From: Michael Burton [REDACTED]
Sent: 03 January 2023 16:26
To: Planning <Planning@arun.gov.uk>
Subject: Objection to AL/31/22/PL

Written submission for Planning Committee 11th January 2023

I write to object to Application AL/31/22

VISIBILITY SPLAYS AT ACCESS
2M X 23M AND 2M X 15M

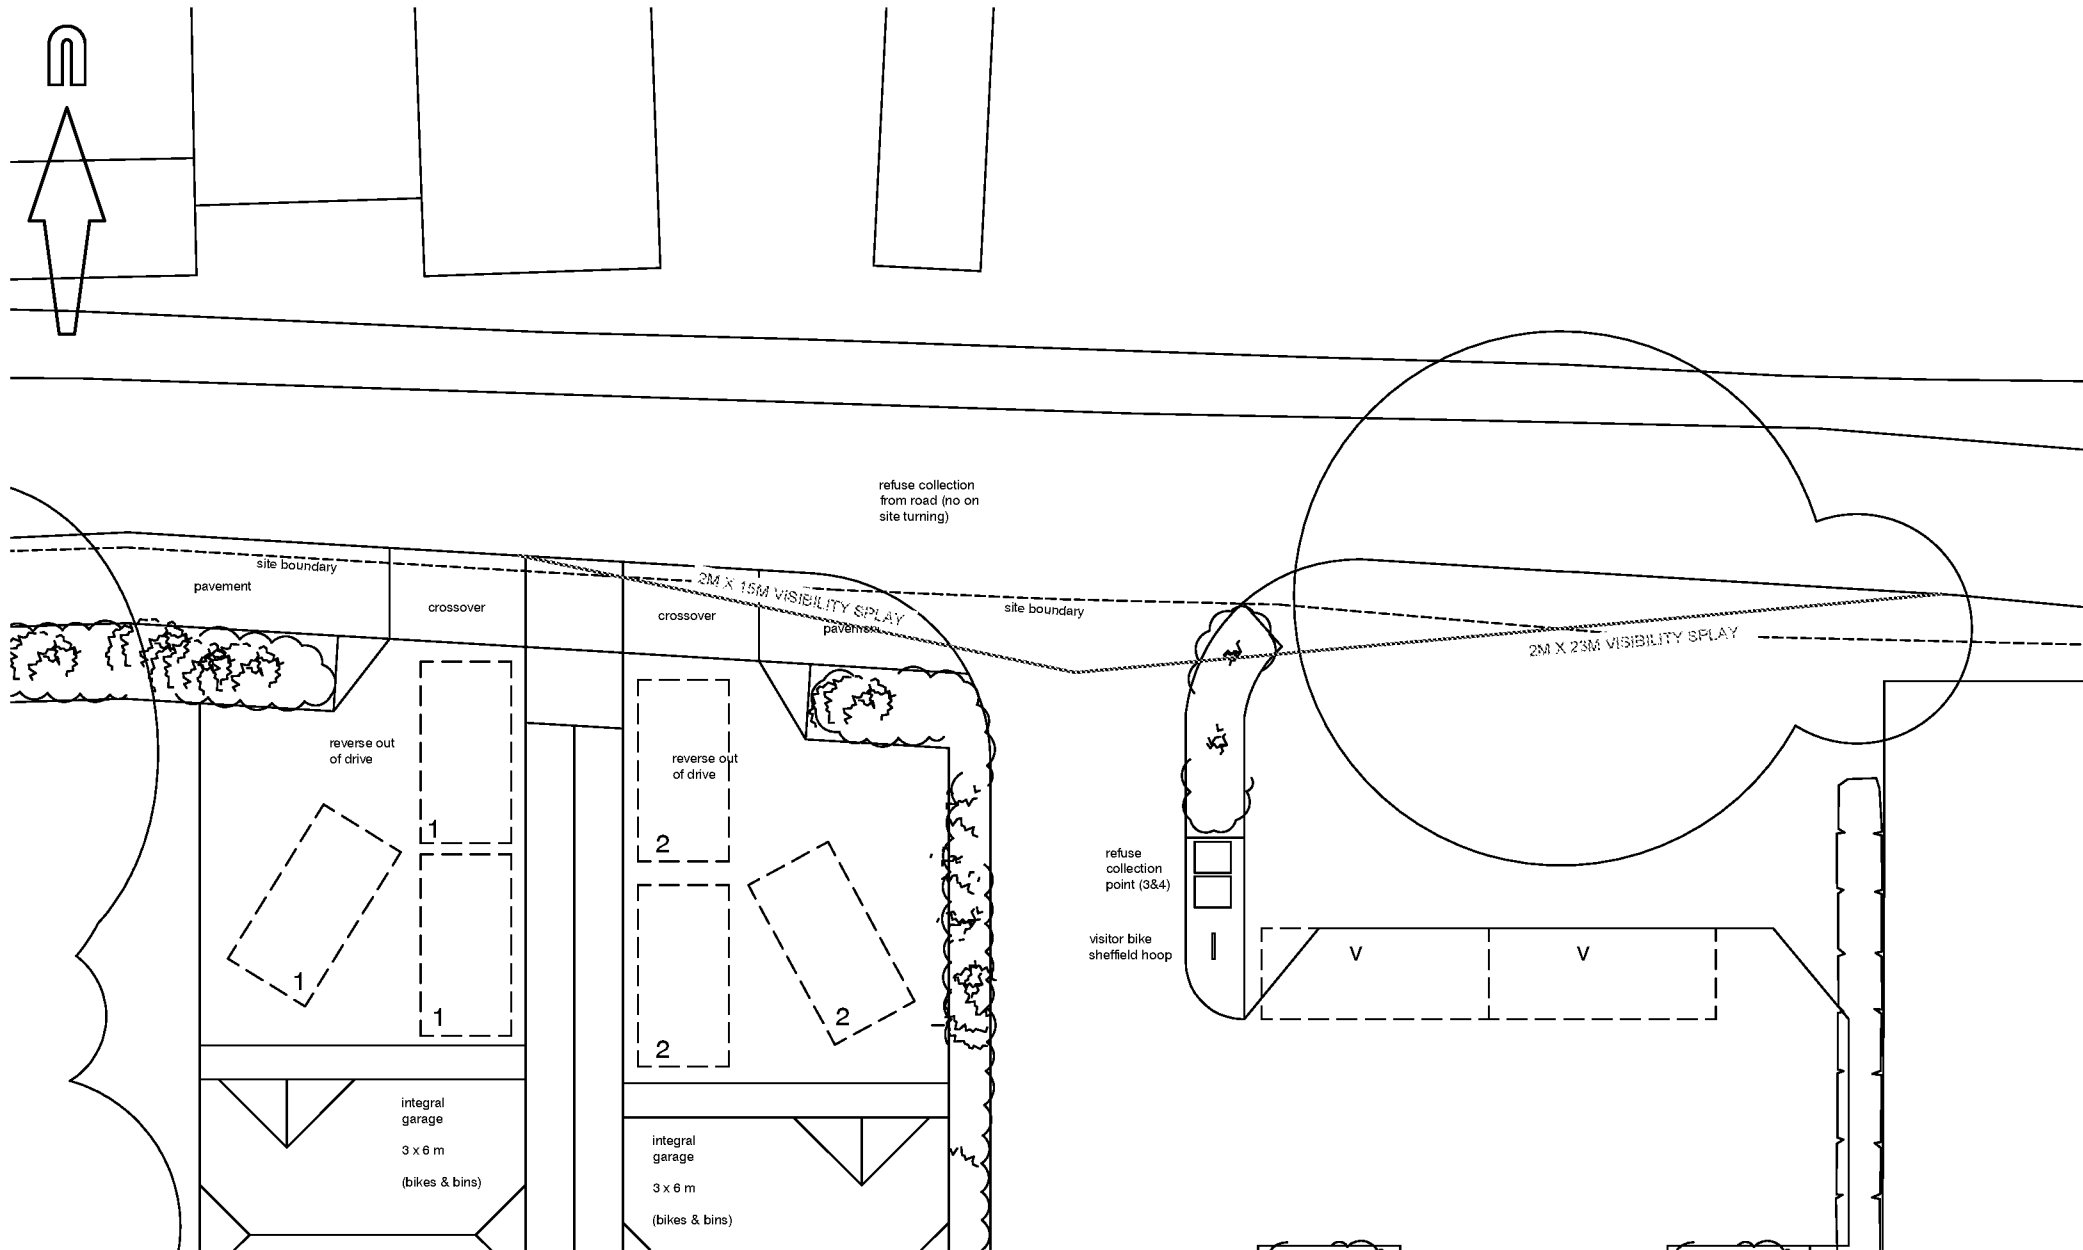
In this application the developer has stated he will provide a "joined-up" footpath, between the proposed development and the already established Oak Tree Lane estate. The developer however has failed to offer any plans as to how this will be achieved; especially as the existing footpaths, of the Oak Tree Lane Estate and the proposed development site, do not abutt one another.

At the Appeal of the previous application (AL/72/19) the Inspector stated, with regards to this specific point, **"...notwithstanding its relatively short length, the uneven surface of the track would not be suitable for wheelchair users, nor would it be suitable for blind or partially sighted people due to the lack of a conventional kerb..... Moreover, the existing condition of the track, in my judgement, would represent a significant trip hazard for blind and partially sighted people. For the reasons outlined above, I conclude that the proposed development would not be accessible to all users other than by vehicle and would not meet the needs of vulnerable users...Furthermore it would also fail to meet the Framework's requirement..."**

I would add that the uneven surface also makes it impossible for the passage of a baby's pushchair, buggy or pram.

Figure 4: Proposed site plan

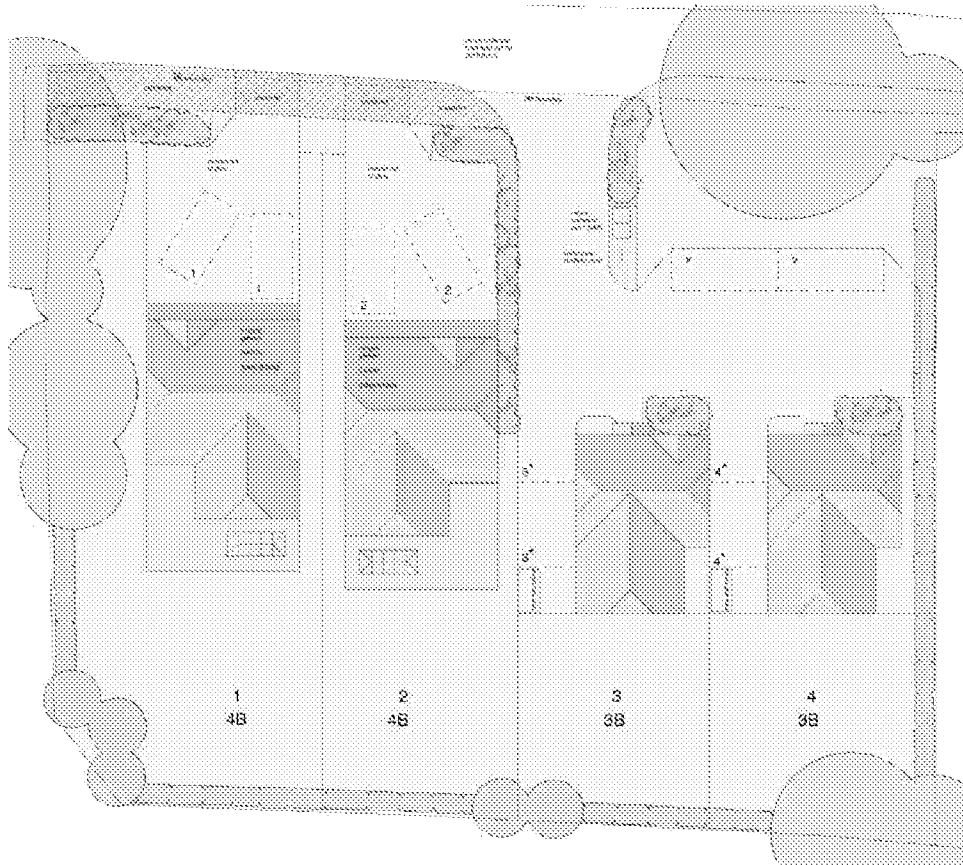
Perhaps this would be the correct time to state that the 'Plan' of the site, submitted with this application, by the developer, is incorrect. The boundary shown on the plan, which links the northwest corner of the proposed development site to Oak Tree Lane is 'misplaced'.

It is submitted that the line on the plan shows the position of a metal gate, set back from the boundary line, not the boundary.

This 'neck' of land, between the western boundary of the proposed development site and the eastern boundary of Oak Tree Lane was originally also a part of the garden of Ryefields Farmhouse. It was purchased by a previous owner of the Woodgate Centre. The northern boundary of this neck of land is therefore where it joins the trackway of East Reads Lane/Oak Tree Lane. This is highly relevant to the matter of pedestrian access to the site.
